CITY OF ALBUQUERQUE

RE: Oso Bio Syringe Line

Grading Plan for Building Permit 4401 Alexander Blvd

Engineer's Stamp Date 7/31/17 Hydrology File: F16D003B1

C1.0

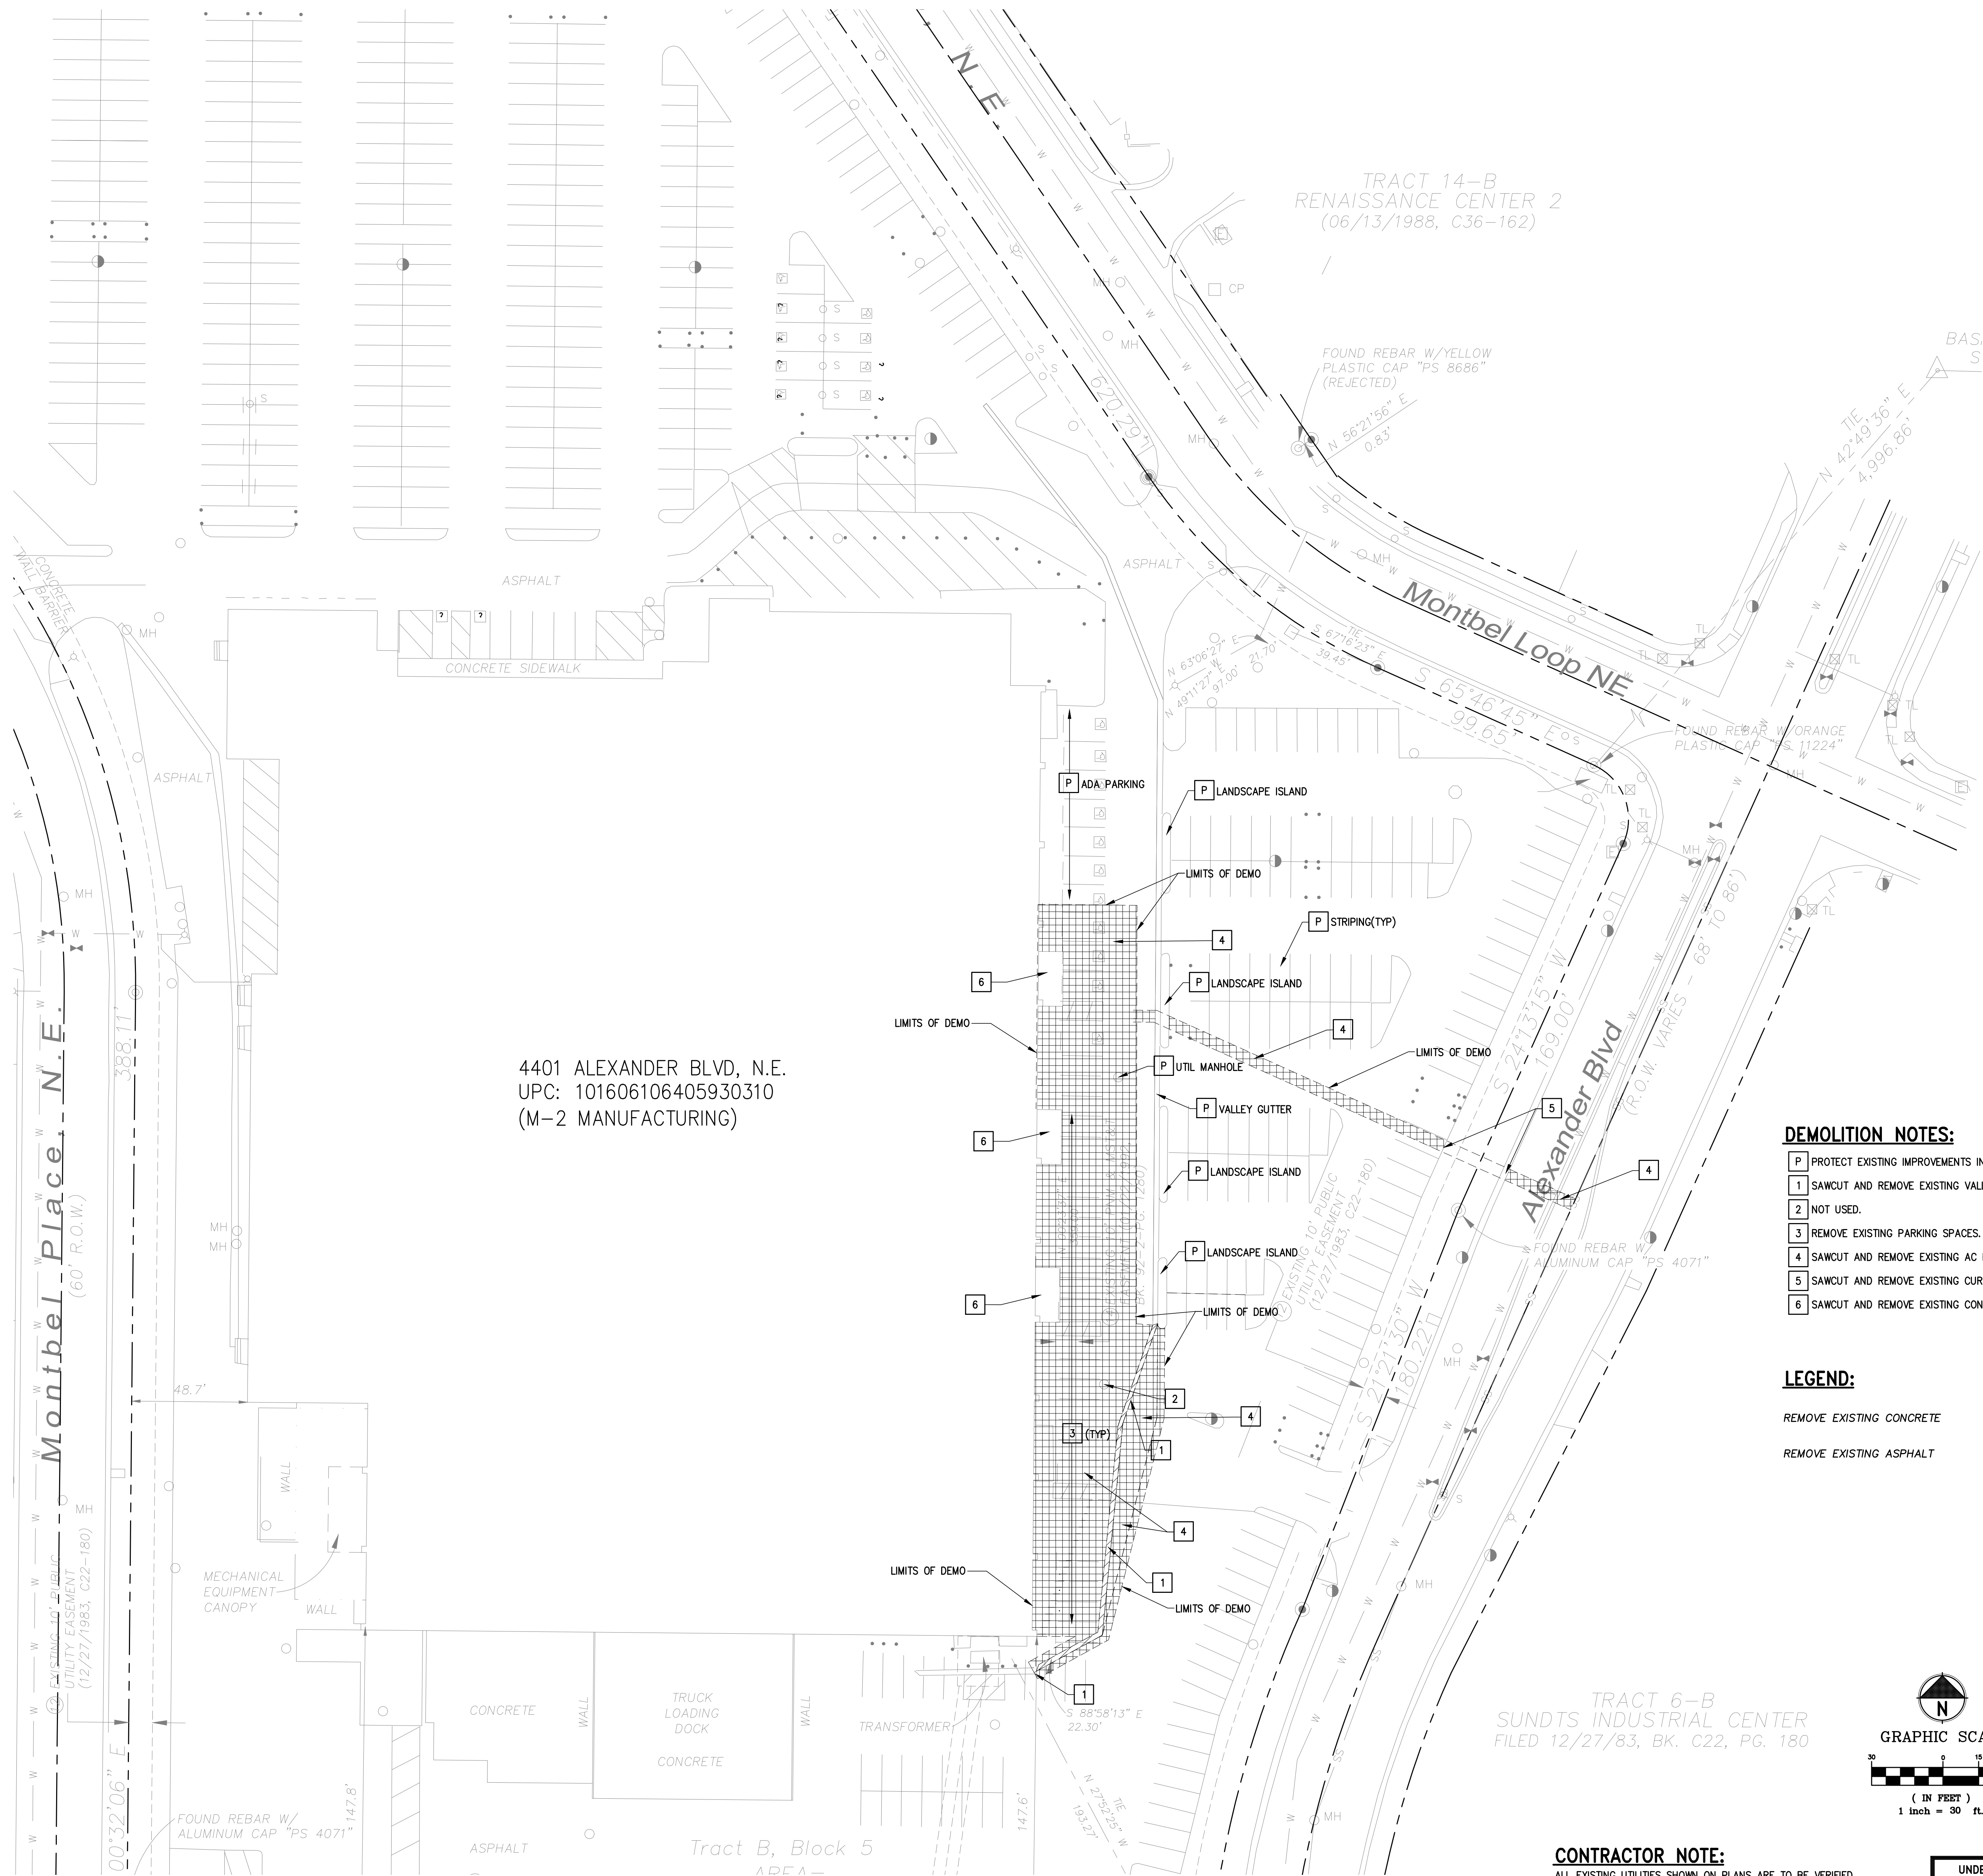
Based on the information provided in the submittal received on 8/9/17 the above-referenced Grading Plan is missing and cannot be approved for Building Permit. A G&D Plan must be provided when Paving 2000 sf. or more and for buildings of 1000 sf. or more. After the Grading and Drainage Plan is approved by Hydrology it should be inserted into the Building Permit application. The Grading and drainage plan should address the following:

- 1. It should include a zone atlas map showing the location of the site, a legal description, and show the limits of disturbance.
- 2. Provide a narrative that describes the allowable 100 year peak rate of storm water runoff (32 cfs) from block 5. All of Tract B and a portion of Tract A drains into the pond and the other portion of Tract B free discharges less than 32 cfs. Describe the pond discharge rate (1.08 cfs) as being less than the 0.1 cfs per acre allowed.

- 3. The required pond volume must be recalculated based on the actual area draining to it. The as-built pond volume calculations should include a table with the area of the contours, and volume calculations using the conic method.

- 4. Both existing and proposed elevations in all areas of construction. If it is your intent to match existing grade then add notes instructing the contractor to match existing grade and/or the existing floor elevation(s) instead of actual spot elevations.

- 5. Provide detailed topographic survey of the three entrances and the pond. The topo survey should extend far enough into the parking lot so to include the entire limits of the 100 year spread of water. Both at the pond and at the entrances.

- 6. Include hydraulic capacity calculations at each of the three driveways on the north as necessary to insure that the onsite drainage reaches the pond and none of it runs offsite at the driveways.

- 7. A pond maintenance plan and schedule of inspections should be specified on the G&D Plan.
- 8. The pond must be cleaned and inspected prior to Certificate of Occupancy. All trees should be removed from the embankment, dead limbs should be removed, and the outlet structure should be uncovered and reconstructed to prevent clogging. An Engineer's Certification will be required prior to Certificate of Occupancy.
